FINDINGS OF FACT AND CONCLUSIONS OF LAW Mostofi Zoning Setback Variance VA-16-00001

This matter having come before the Kittitas County Community Development Services for the Mostofi Zoning Setback Variance (VA-16-00001) submitted by Aaron Mostofi to reduce 200 foot setbacks within the Commercial Forest Zone to 50 feet on the northwest and southeast borders and 10 feet on the southwest border. This variance is in order to facilitate construction of a cabin, a garage, and a shed/workshop, along with associated wells and septic systems.

VA-16-00001

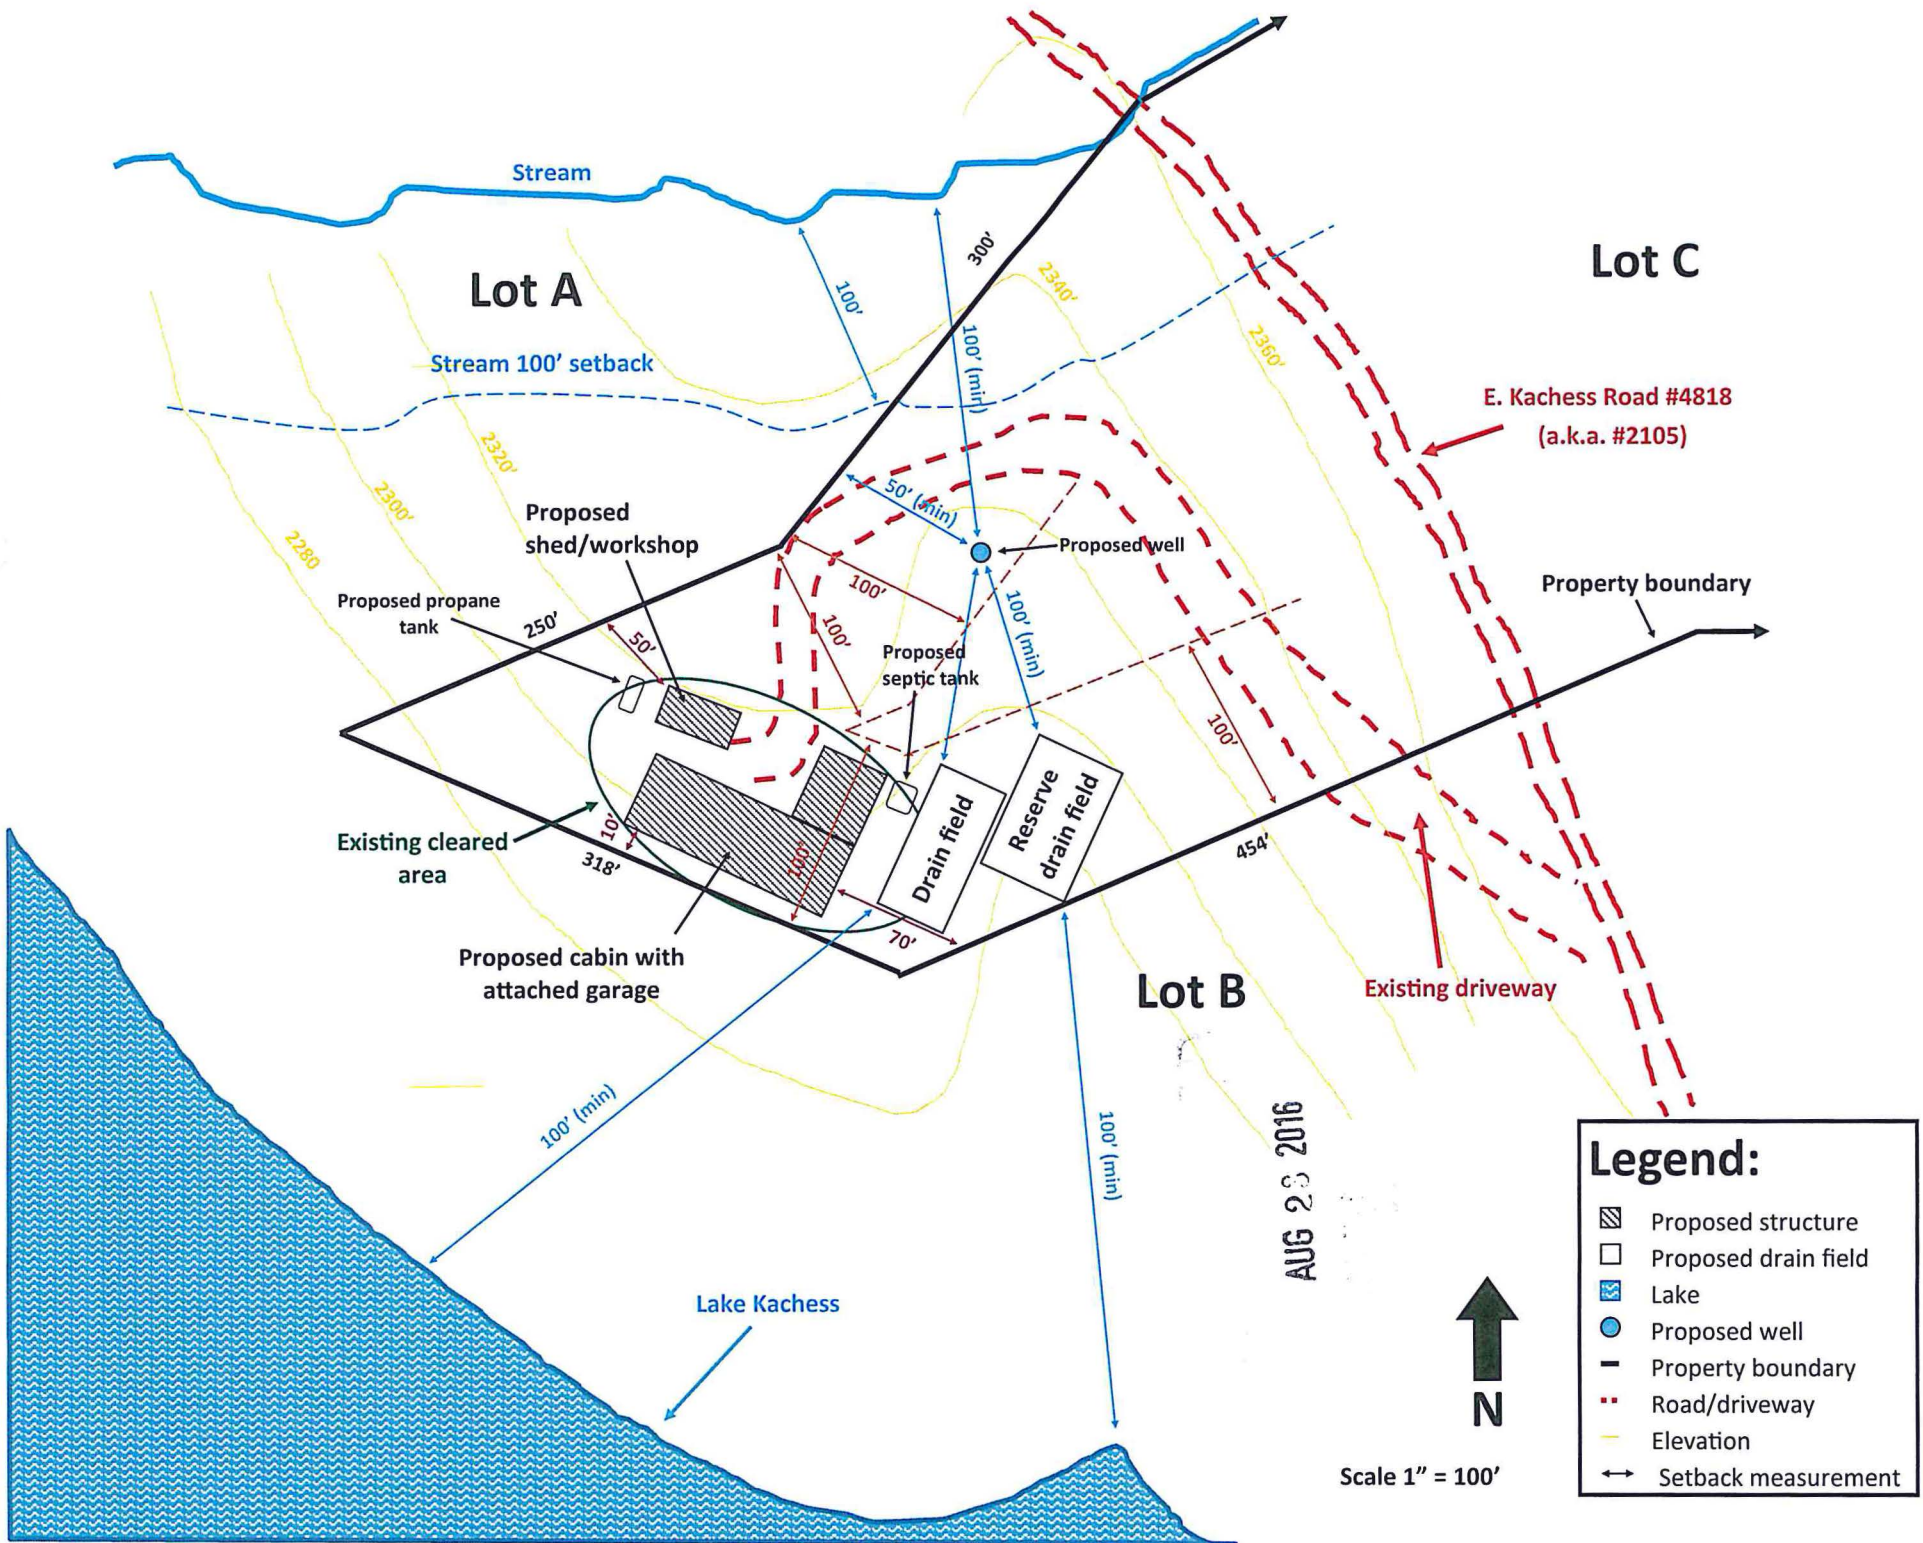
4. The Department of Ecology responded with a letter dated September 12th, 2016. The letter states, in part :
"Approval of this development may require a shoreline variance permit if any development (including any appurtenances such as garages or sheds) occurs within the 100-foot setback from the OHWM of Lake Kachess or within required buffers from wetland areas. The project will require a shoreline permit exemption action if the development will occur within 200 feet of the OHWM. No mention is made regarding what the shoreline designation of this shoreline area is. The submitted map shows only that the setbacks will be "a minimum of 100 feet back" from the OHWM. A map that is adequate for shoreline review and filing purposes should show actual distances. Measurements taken via a google earth pro application show the cleared area being a little bit more than 200 feet from the visible lake level. The managed Lake level will be lower in elevation and below the OHWM due to wind and wave action. It takes a foot or more of water underneath large woody debris to move it. Therefore, the OHWM is typically higher in elevation than the debris line."

Staff used the wetland edge in County GIS files as the OHWM, landward of the edge of Lake Kachess, and a parcel file derived from engineer's CAD Files created during a 2008 boundary line adjustment to analyze the property. Analysis shows the proposed addition .47 feet outside of the 200 foot buffer from the edge of the wetland. In order to add the proposed addition to the GIS files, the site plan was georeferenced with a Root Mean Square Error of +/- 0.78 feet. This level of precision means that the proposed addition could infringe on setbacks from the actual OHWM. In order to ensure that setbacks are respected, the variance is modified to a 12 foot setback from the property line on the west edge of the property from a 10 foot setback.

1. Setback on the west side of the parcel is extended from 10' to 12' in order to accommodate shoreline and wetland buffers.
2. Any new driveway shall comply with Kittitas County Code with driveway lengths over 150 feet to have widths no less than 16 feet. In addition, all new construction must meet the Wildland Urban Interface Code for building components and defensible space.
3. A 100' minimum setback from the fish bearing stream to the north of the property shall be observed.
